Ground floor extension to front
56 Ashurst Way East Preston

Thank you for your internet representation made on 13th December 2012 which has been recorded as '**no objection**' with the comments as follows:

FRONT ELEVATION

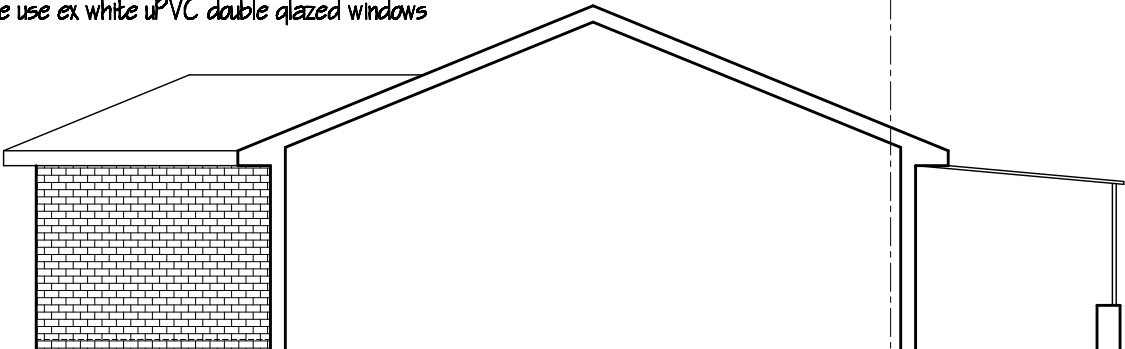
No objection. However frontal treatment should match existing.
